JR ENGINEERING, LLC

FOR APPROVAL JAN 21 2021

LOCATION Tamlin RD., RV Storage / McDonalds Storage

STRUCTURE Pond A Outlet Structure

POND A OUTLET STRUCTURE - PROFILE
SCALE: 3/4\"/>

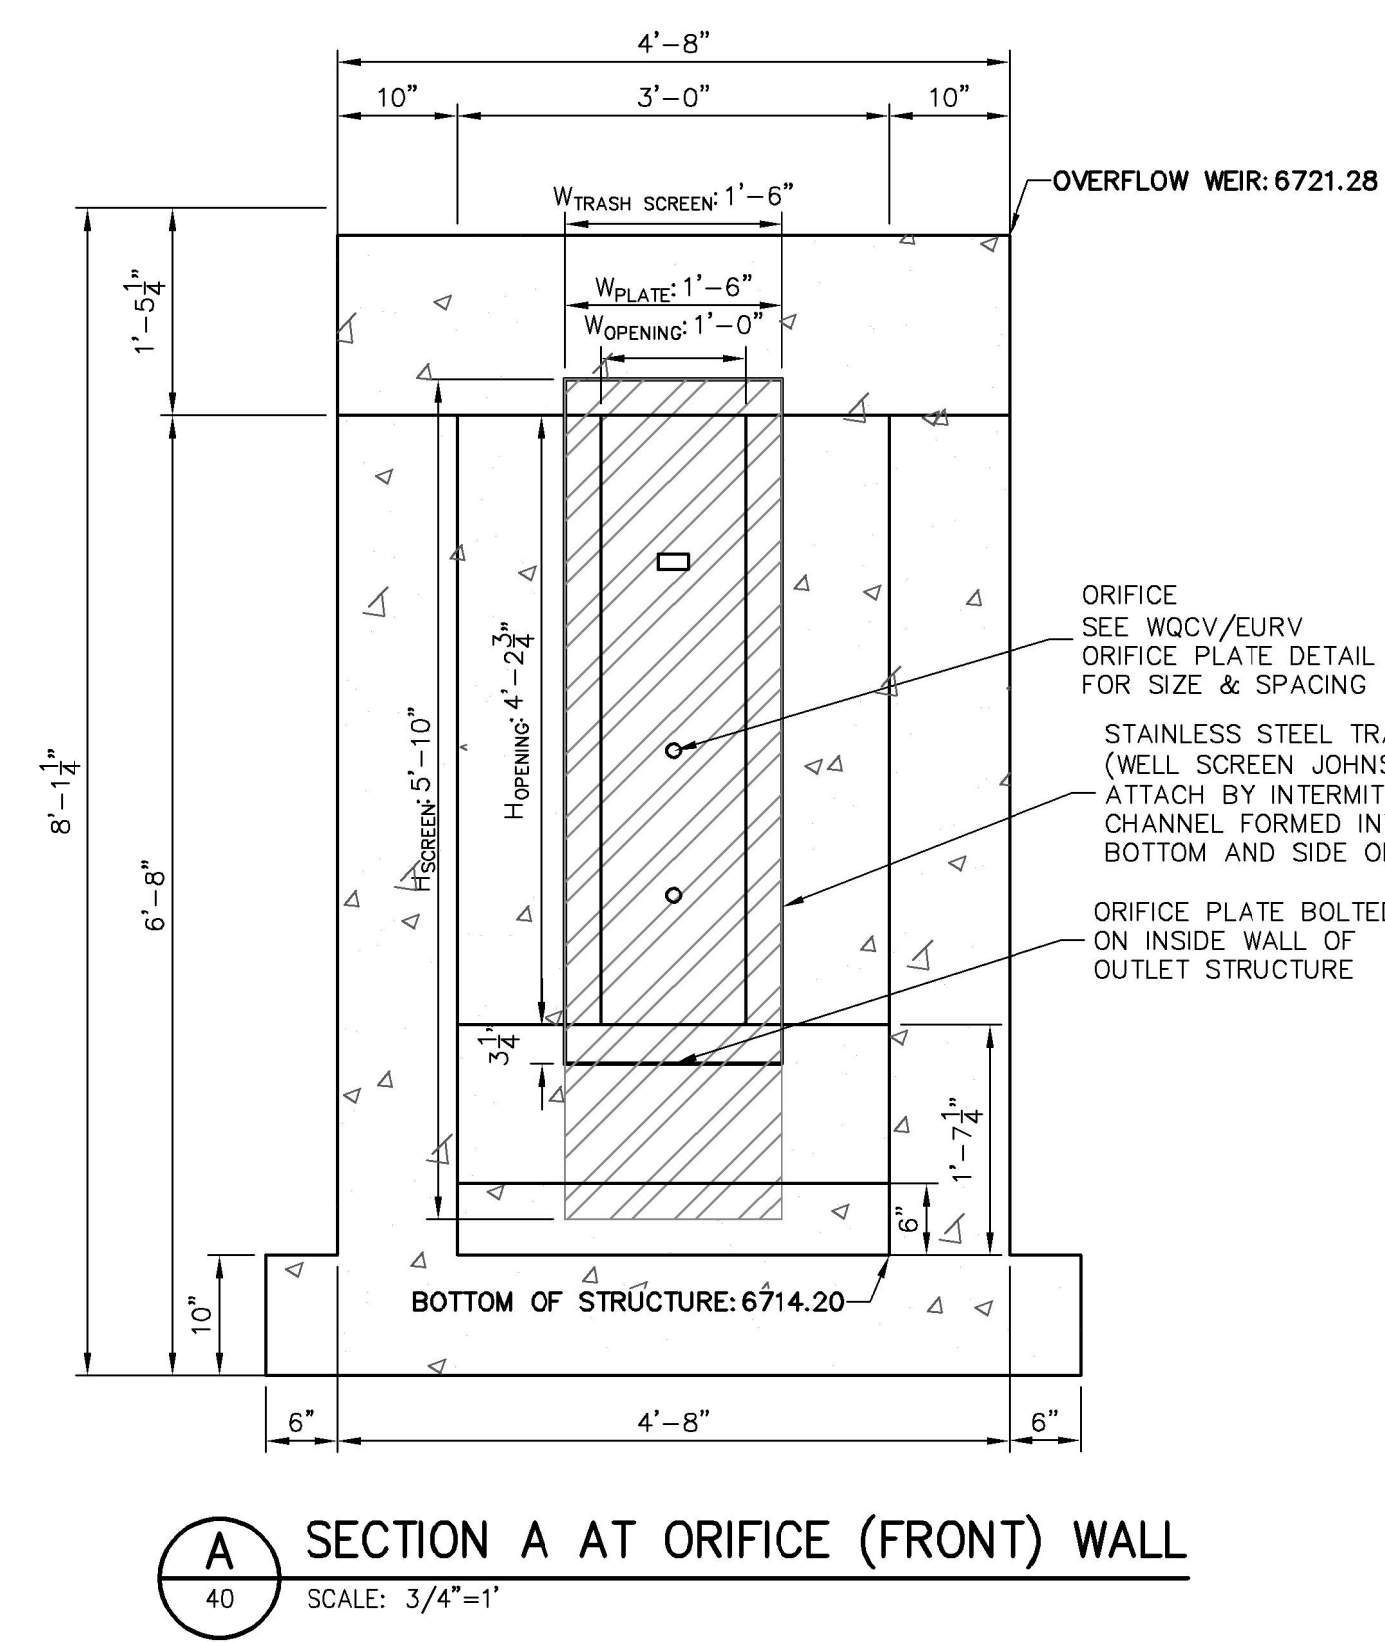
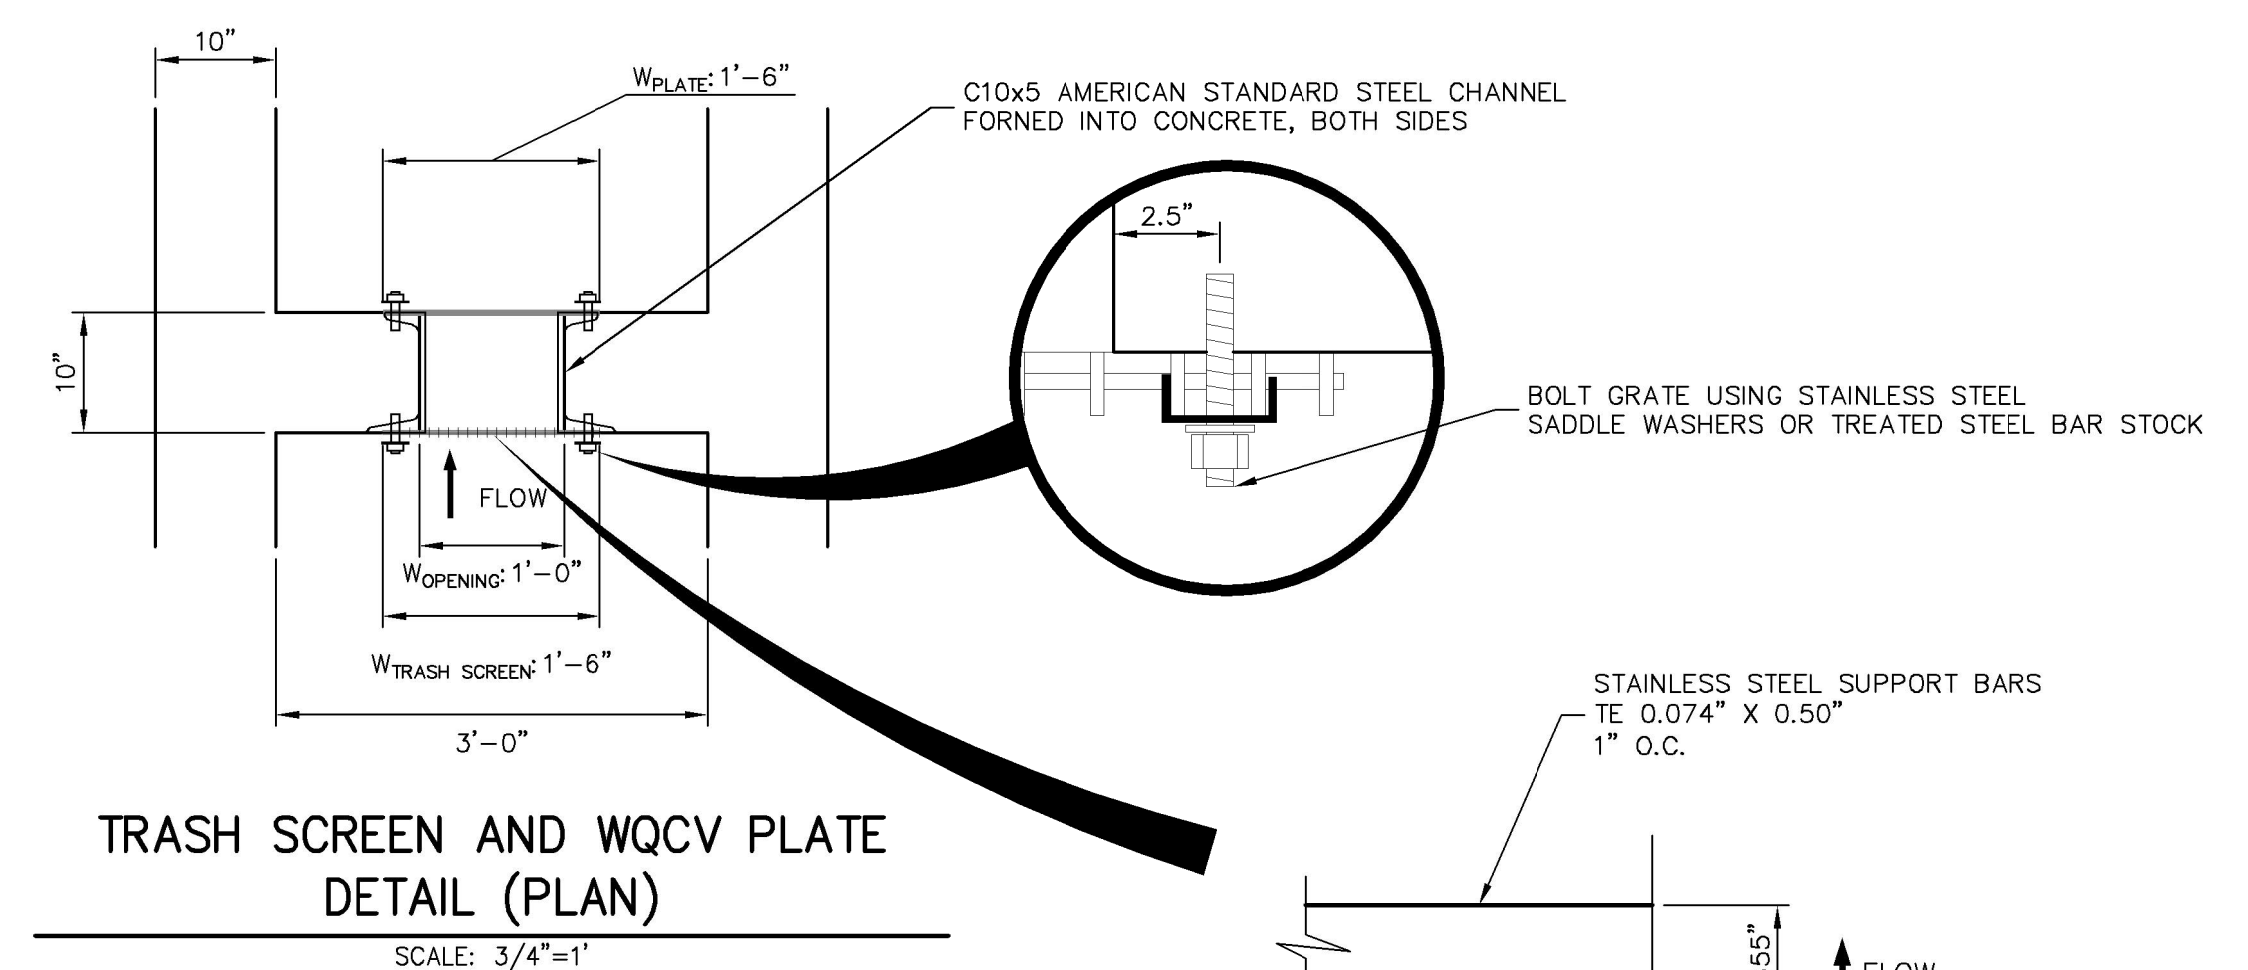
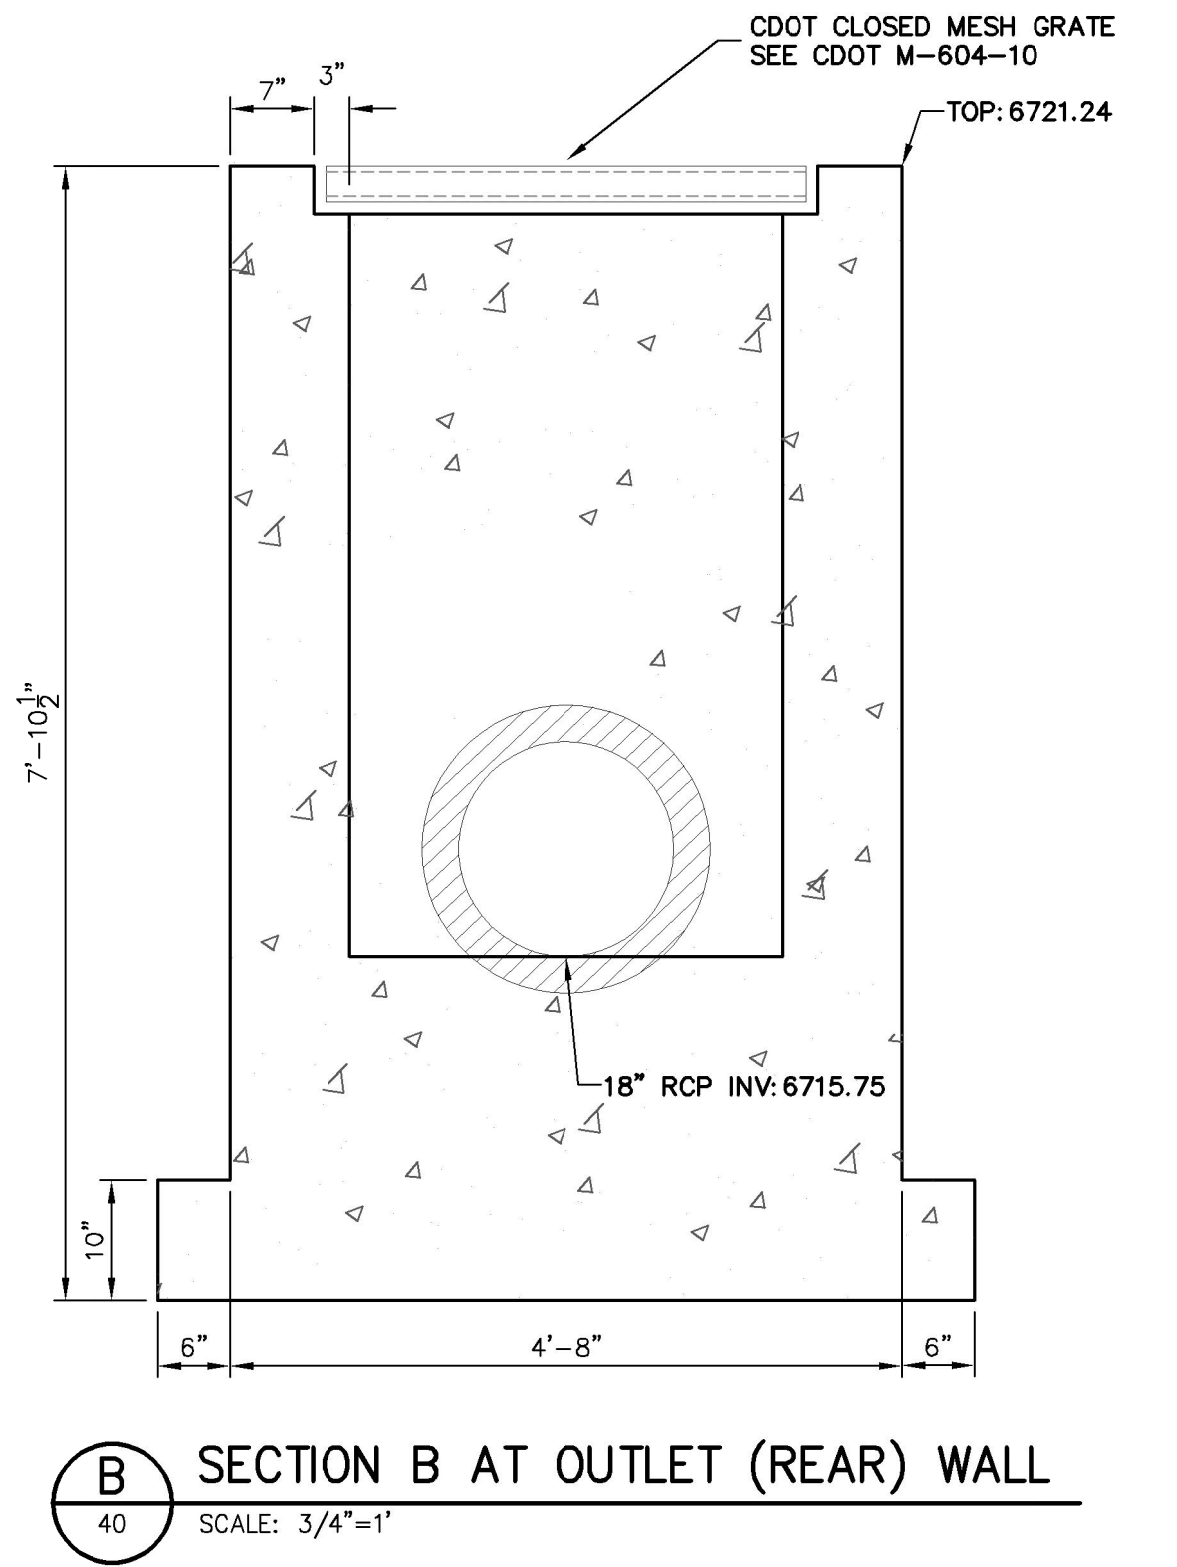
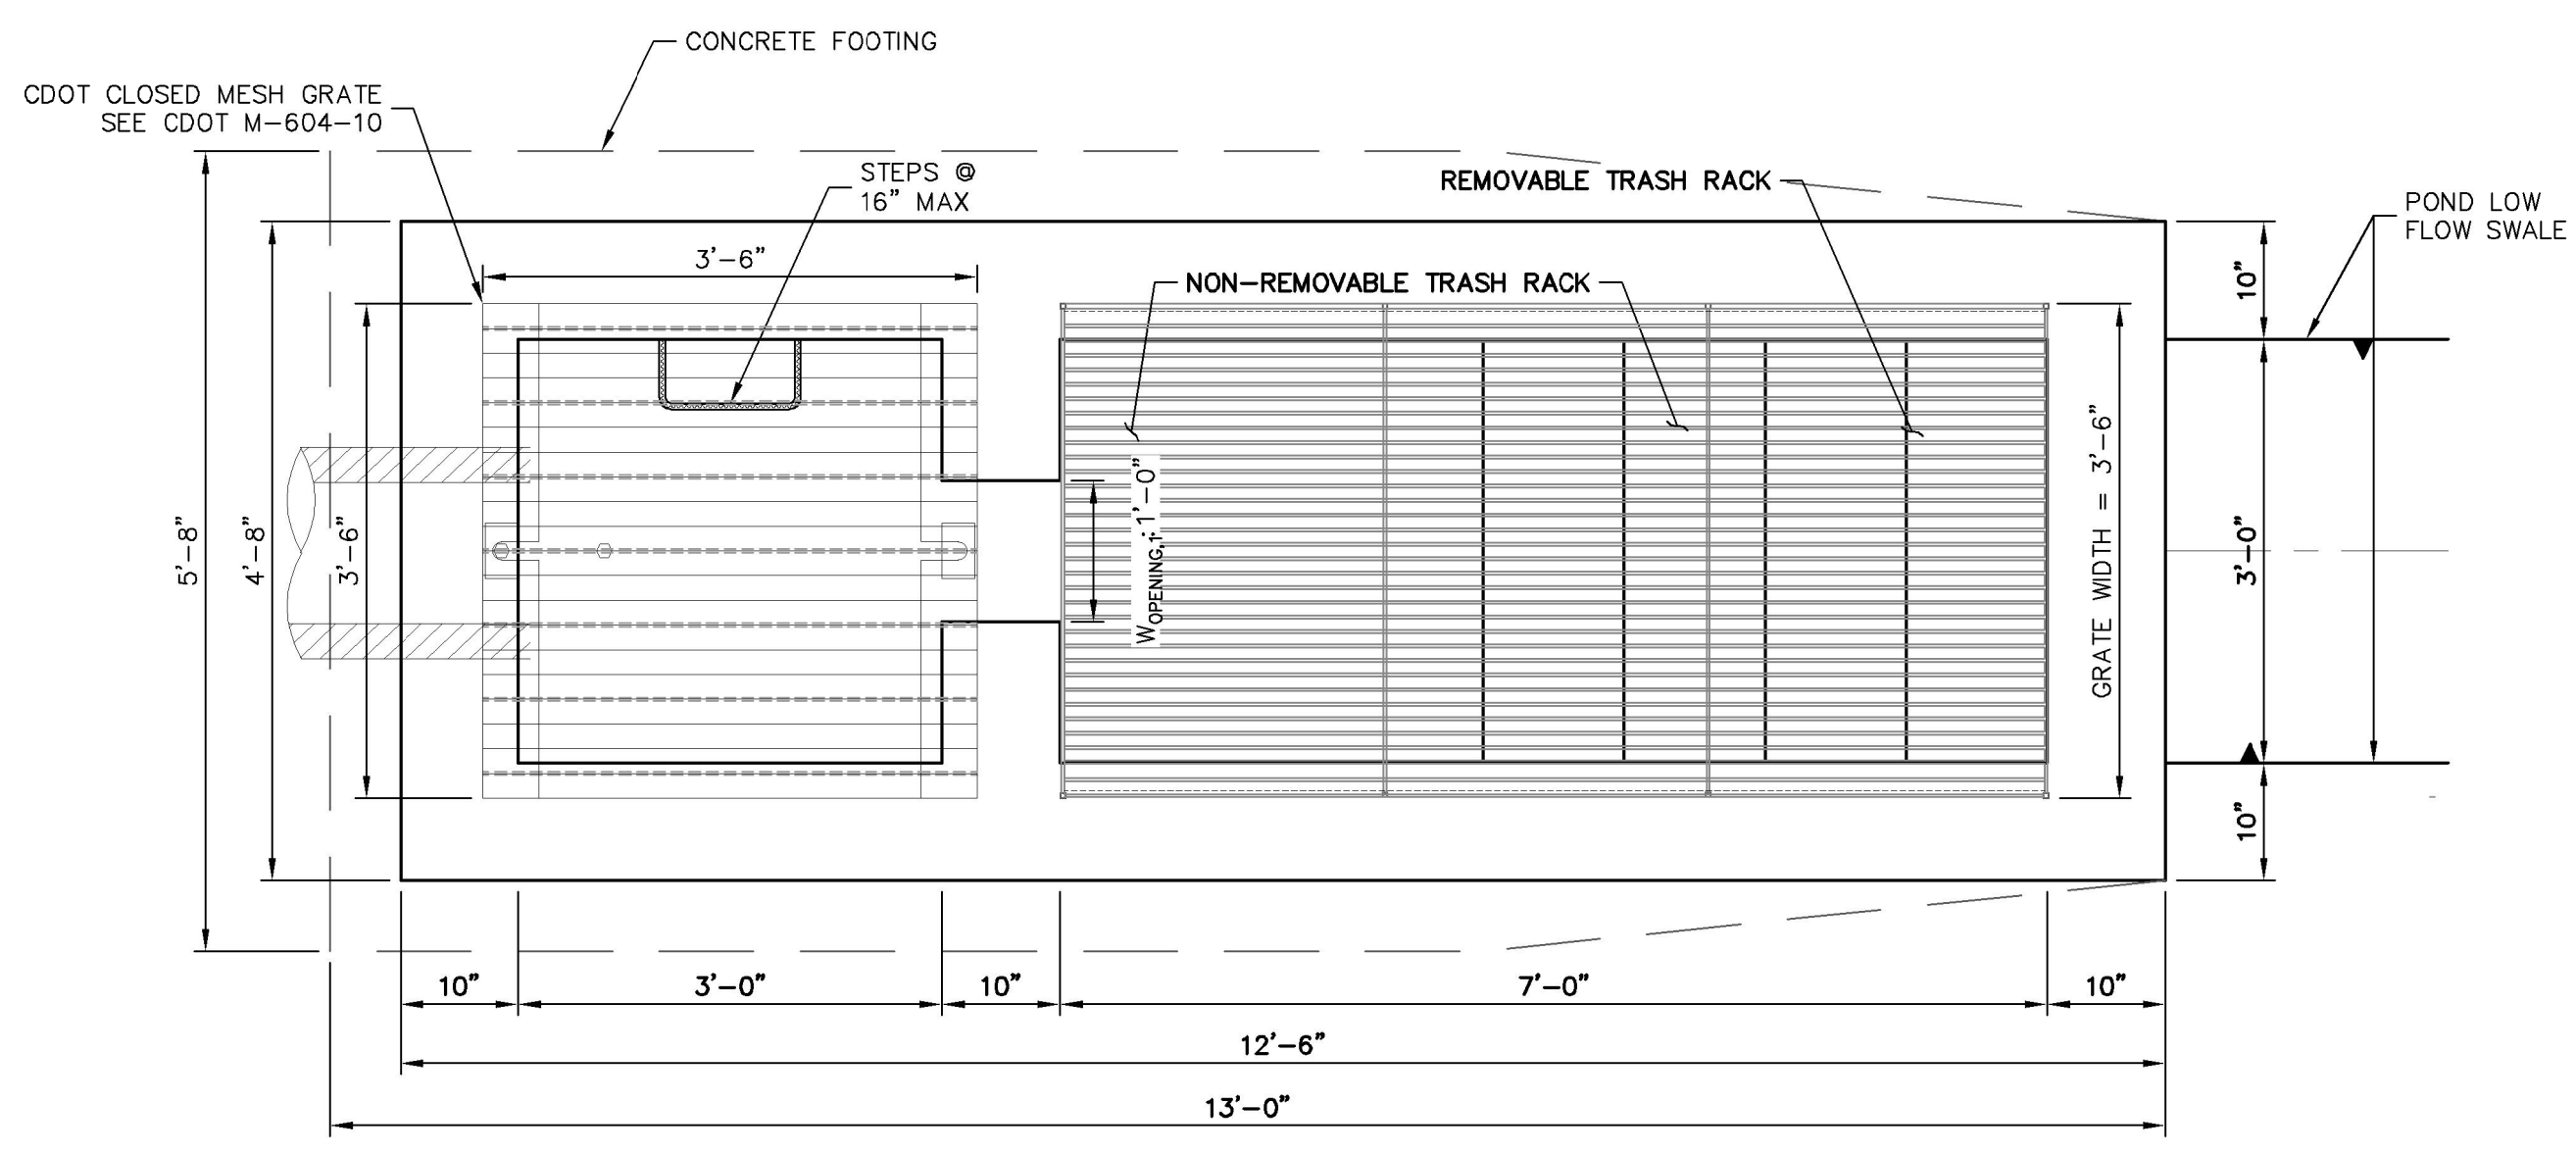
Approver, Please note, the span is greater than 3'-0". Thus, the bearing bars have to run the incorrect direction. Please Verify this is acceptable.
